Date: 8 September, 2014

Memo Report

Subject: Life Safety Code Review for Interim Use of Brick South Building at Thompson's Point

A1.01	Date: 9-2-2014	Scale: 3/32" = 1'-0"	Revisions:	Project: THOMPSON'S POINT- BRICK SOUTH	Architect: ARCHETYPE	Consultant:	Prepared For:
	FIRST FLOOR PLAN				THOMPSON'S POINT, PORTLAND ME	48 Union Wharf Portland, Maine 04101 (207) 772-6022 Fax (207) 772-4056

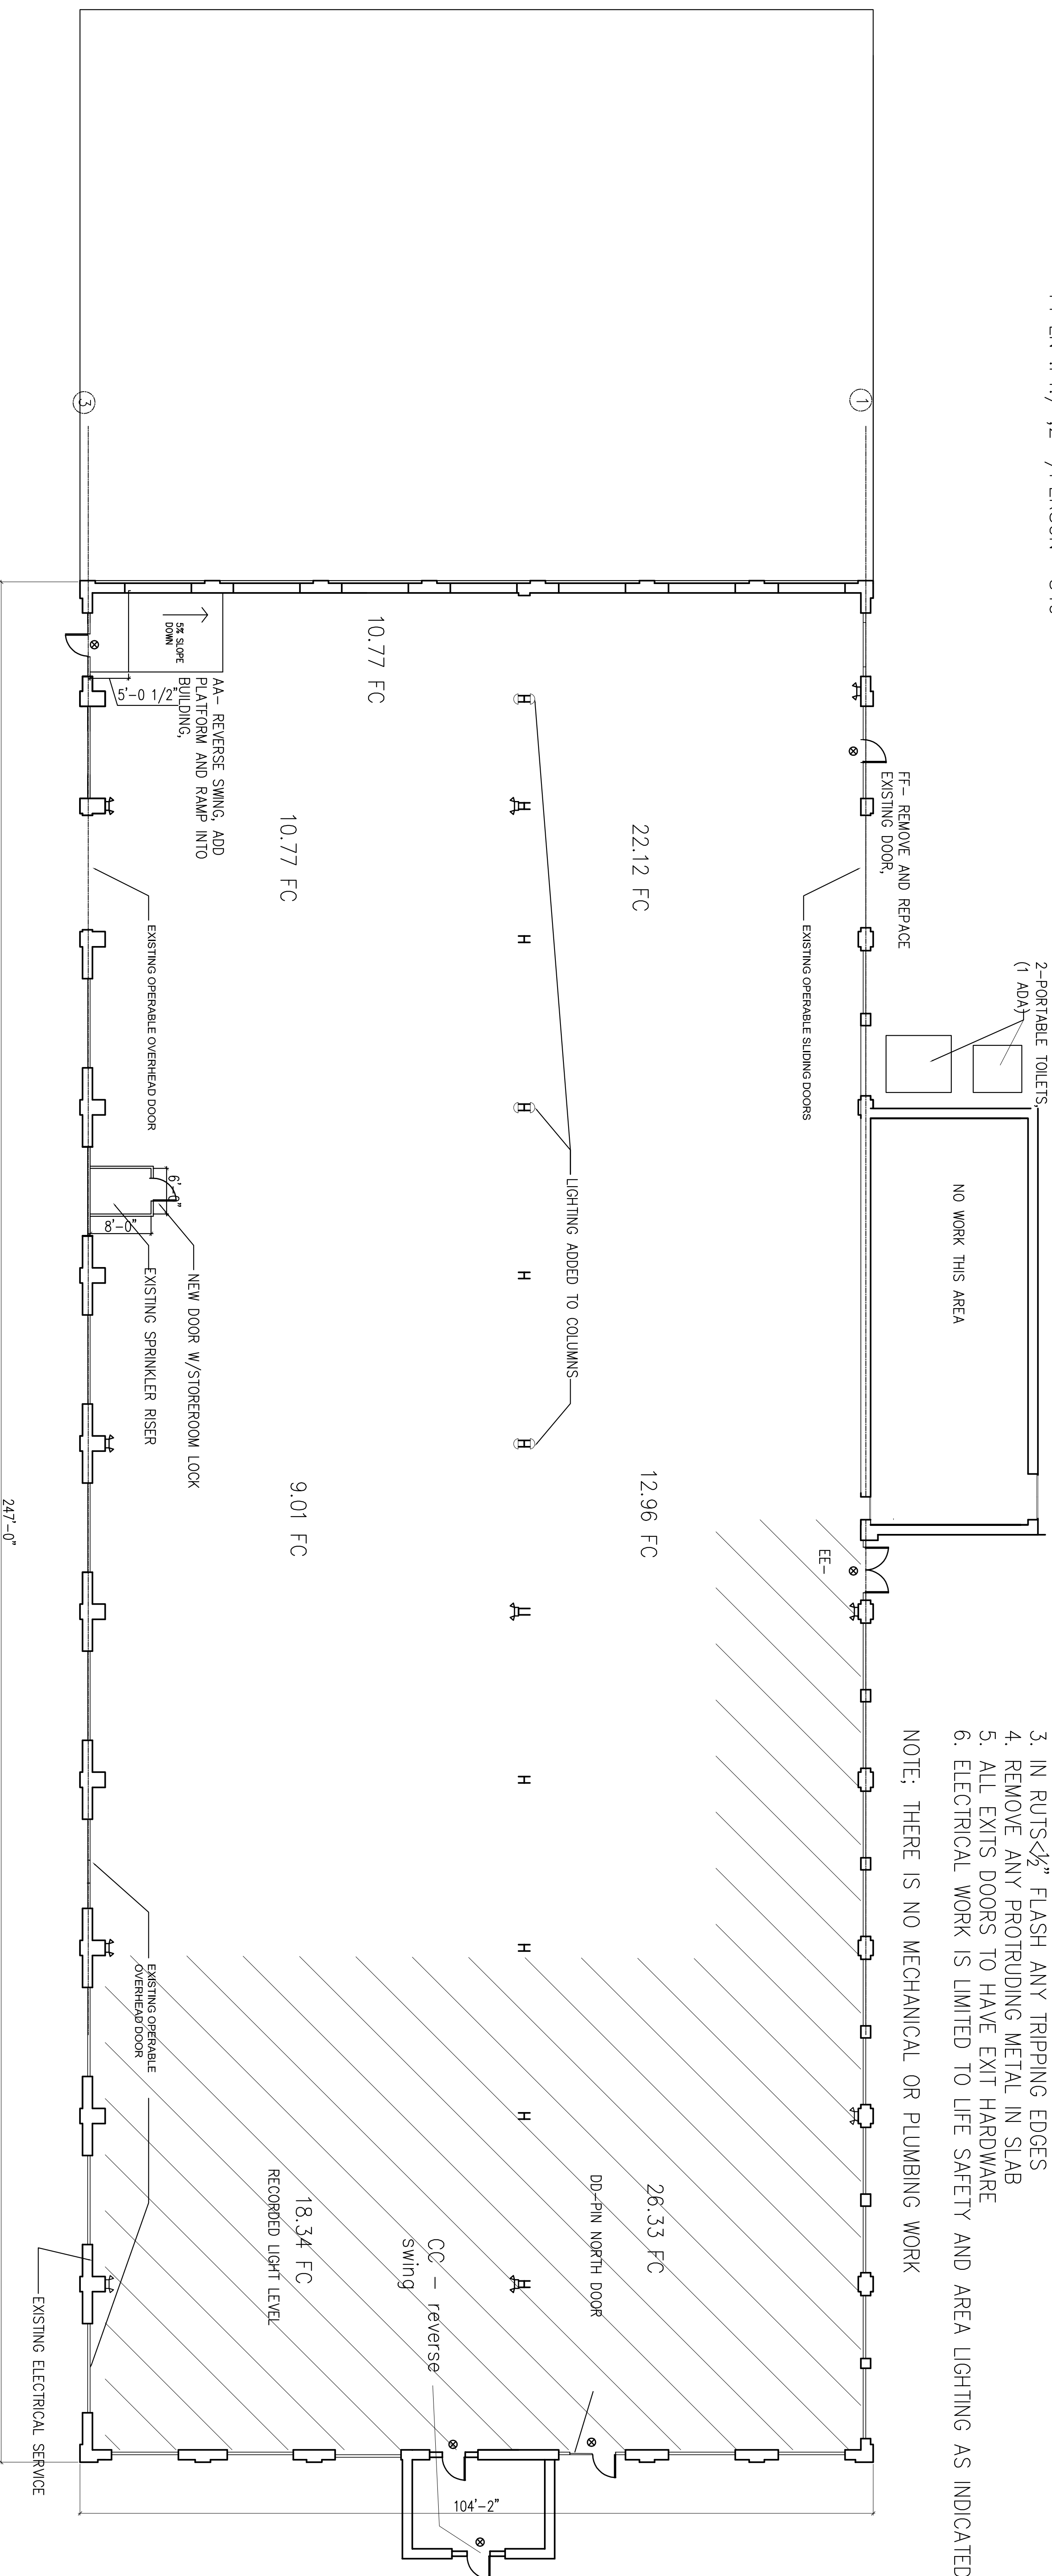
As requested, I reviewed the updated First Floor Plan for the Brick South Building at Thompson's Point; Dwg A1.01, dated 9/2/14. The focus for this review was to perform a "quick" life safety evaluation to assess the potential interim use of this building to act as a "practice facility" of the Circus company. This use would occur prior to any significant modifications being made to the building, including the installation of planned fire protection systems that have been addressed in previous code reviews.

Based on the layout of the building that is shown in the floor plans, it is believed this building can safely be used as an Assembly occupancy without the installation of fire protection systems. The focus for this review was strictly on the life safety aspects and, as such, did not include any requirements outlined in the International Building Code (IBC); albeit as an existing building, this many not be applicable anyway. I realize the use of this building as a practice facility for the Circus personnel would be considered a "change in use", but I believe for its temporary use which will not involve any "audience" (general public) being present, the requirements outlined by the Life Safety Code® (NFPA 101) are appropriate.

When using the requirements for a new assembly occupancy, Chapter 12 of NFPA 101, as long as the occupant load is less than 300, there would be no requirements to install either a fire sprinkler or fire alarm/notification system. Equally, given that the capacity of the 5 exit doors located throughout the perimeter of the building exceeds 1000 occupants, having adequate egress will not be an issue. The maximum travel distance to an exit of 200 feet for a non-sprinklered facility allowed by the Code far exceeds the actual maximum travel distance from anywhere within this building. At this point in time, the primary recommendation I would have regarding the temporary use of this building is to ensure that proper emergency lighting and exit signage are provided in accordance with code requirements prior to allowing any use/occupancy of this building.

This building consists of one large, open space. Even if a fire could/did occur, it would be readily obvious to any occupant in the building; allowing for their immediate travel to the nearest, unobstructed exit. This, coupled with the fact that it has been indicated that it's likely there will be less than 50 people in this building at any one point in time during this interim period, indicates that the use of this building as a practice facility by the Circus personnel does not appear to put them at any undue risk to life safety.
